CITY OF ALBUQUERQUE

February 6, 2024

Re: Transport Apartments
2900 Transport St. SE
Traffic Circulation Layout
Engineer's Stamp 01-23-24 (M15-D023H)

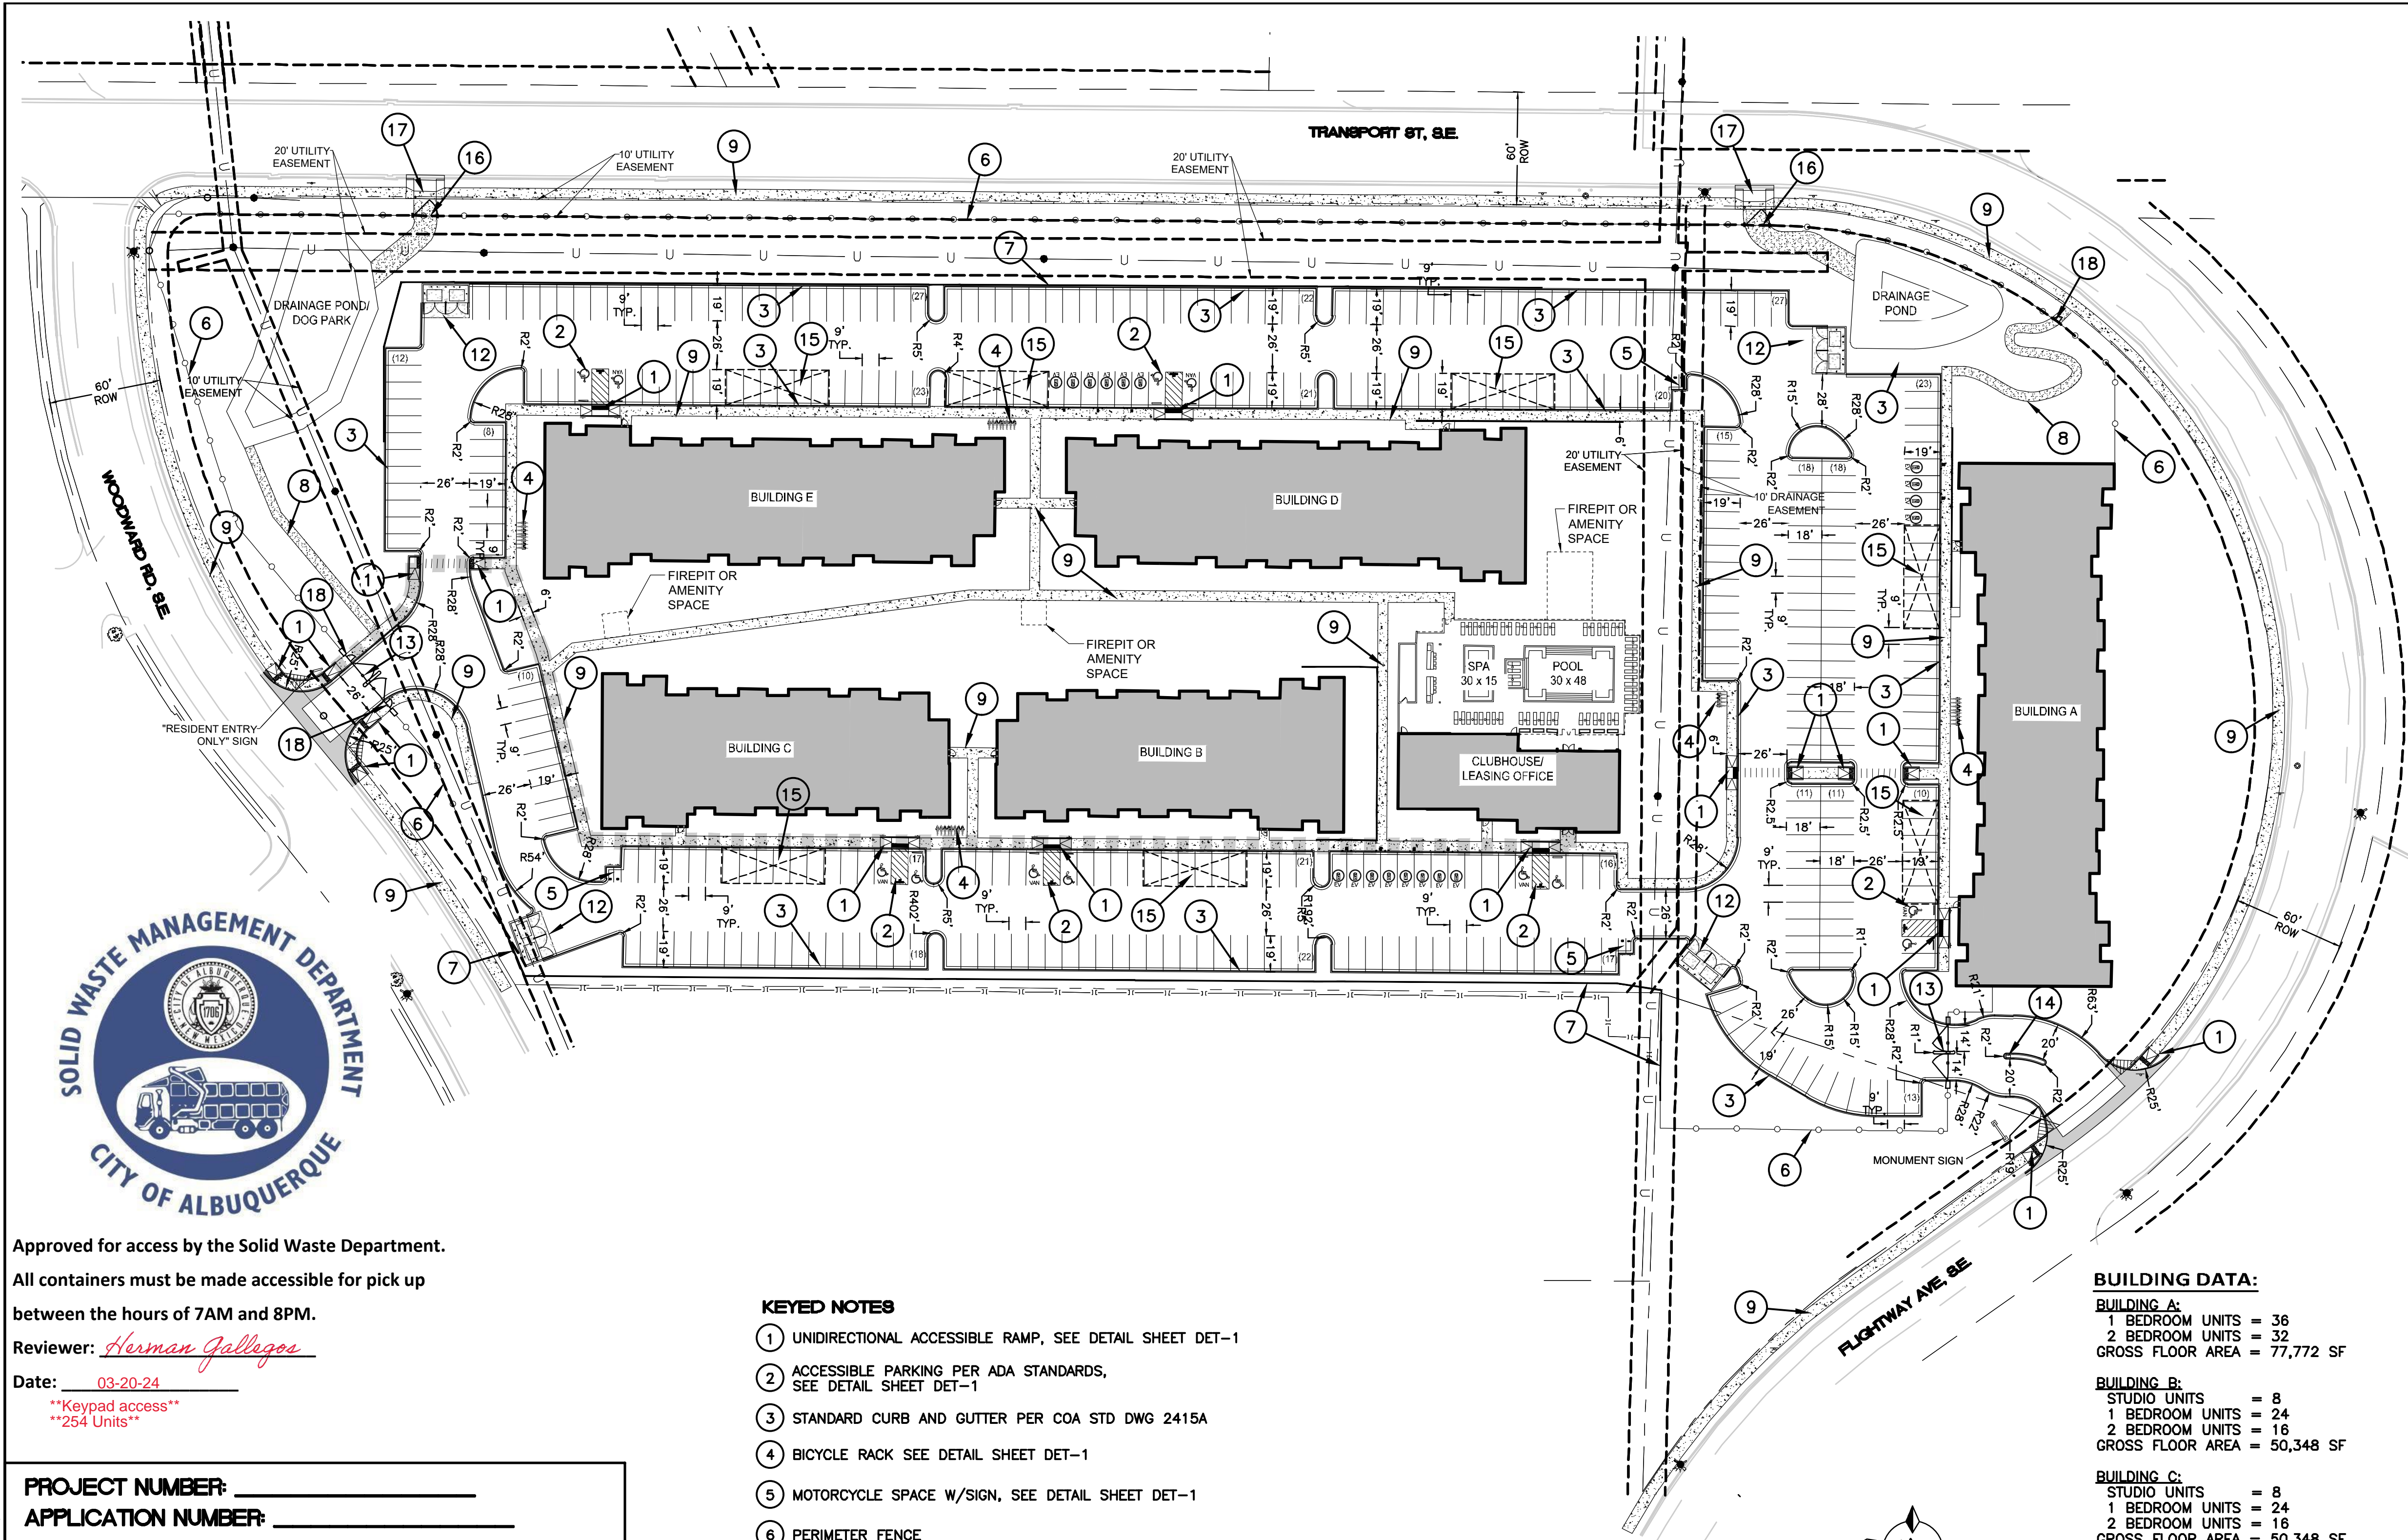
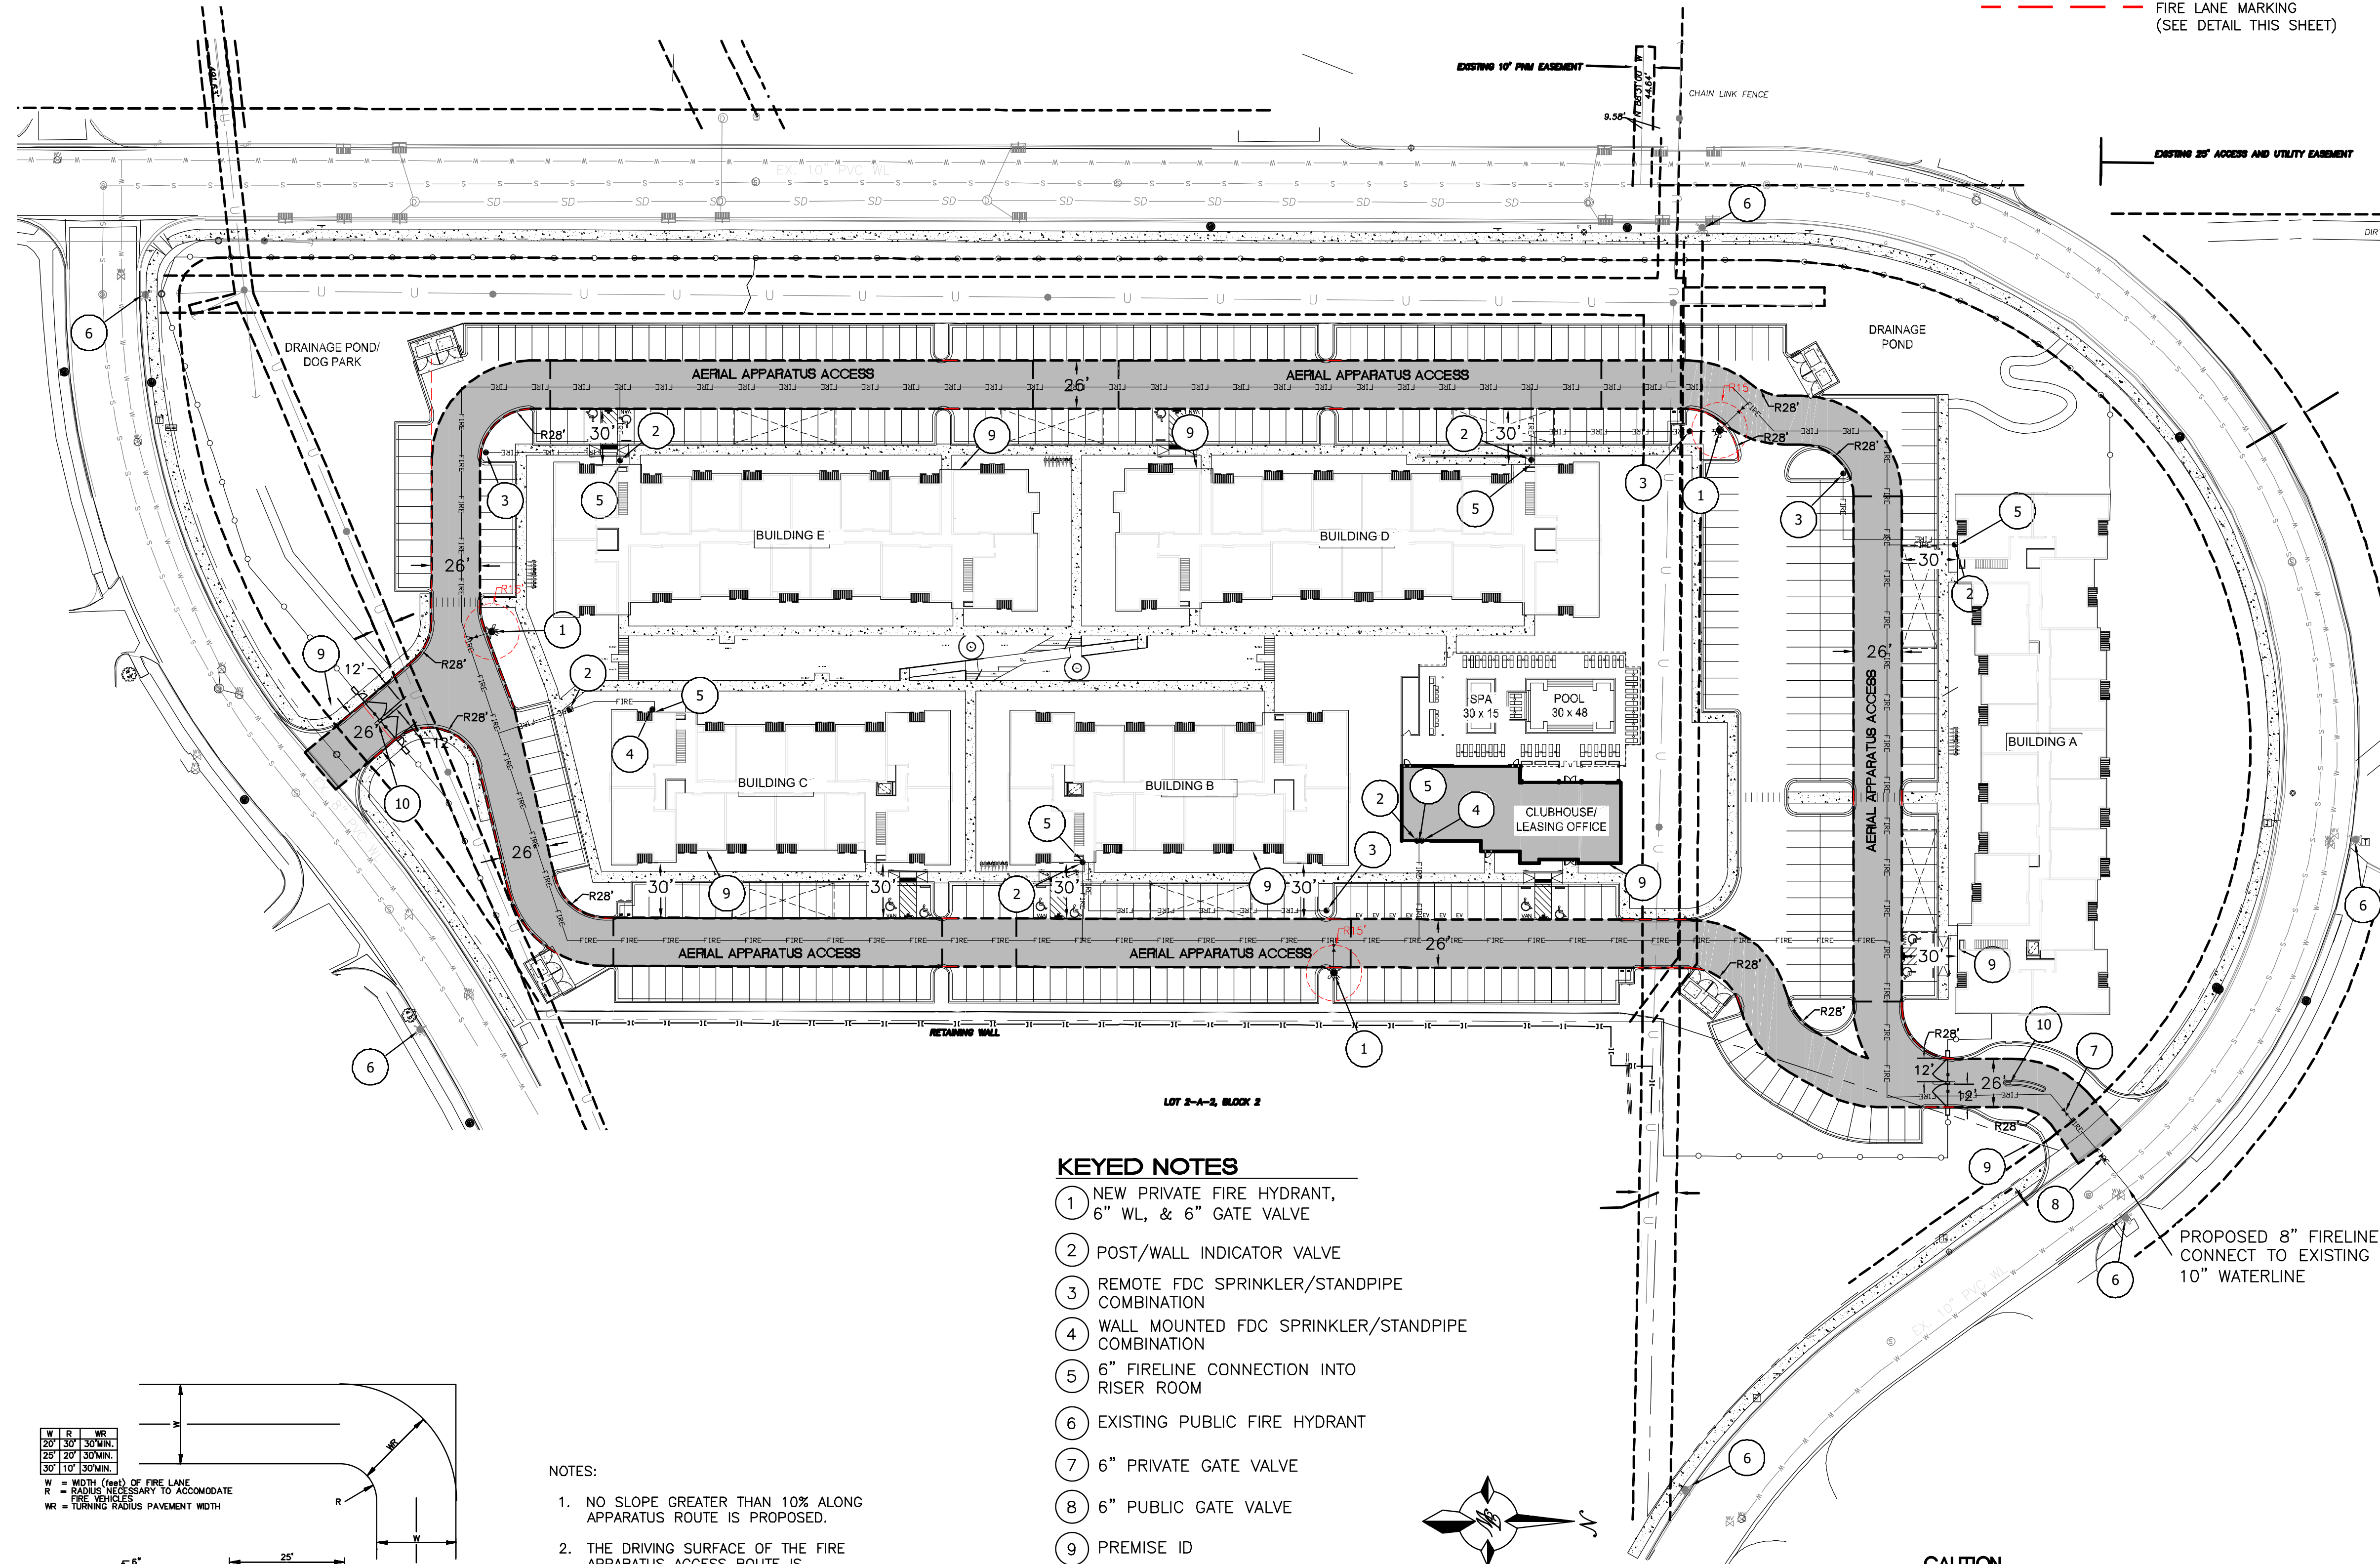
1. Identify the right of way width, medians, curb cuts, and street widths on Transport St. and Woodward Rd. SE.
2. Provide right of way improvement details:
 - Proposed sidewalk and buffer width and design details.
 - Proposed ADA ramp at the corner of Transport St. and Woodward Rd. details.
 - Proposed both site accesses details.
3. Per the DPM, please indicate a minimum throat length of 75 ft. for both site accesses.
4. Drawing is missing keynote 2.
5. Are you providing EV parking spaces less than the required number? Please address this concern.
6. Provide proposed standard parking spaces width.
7. Parking spaces at the east side of building A are out of the property.

8. Key note 10: is it a median?
9. Please provide details for the sidewalk in this area.

10. Please show on the site plan the width of the ADA pathway from the public sidewalk to the building entrance.

11. Key note 13: Due to proposing a gate, please provide vehicle turning around template.
12. Provide a copy of Fire Marshal and Solid Waste approval.
13. Traffic Studies: See the Traffic Impact Study (TIS) thresholds. In general, a minimum combination of 100 vehicles entering and exiting in the peak hour warrants a Traffic Impact Study. Visit with Traffic Engineer for determination, and fill out a TIS Form that states whether one is warranted. In some cases, a trip generation may be requested for determination (**Contact Matt Grush: mgrush@cabq.gov**).
14. Please provide a letter of response for all comments given.
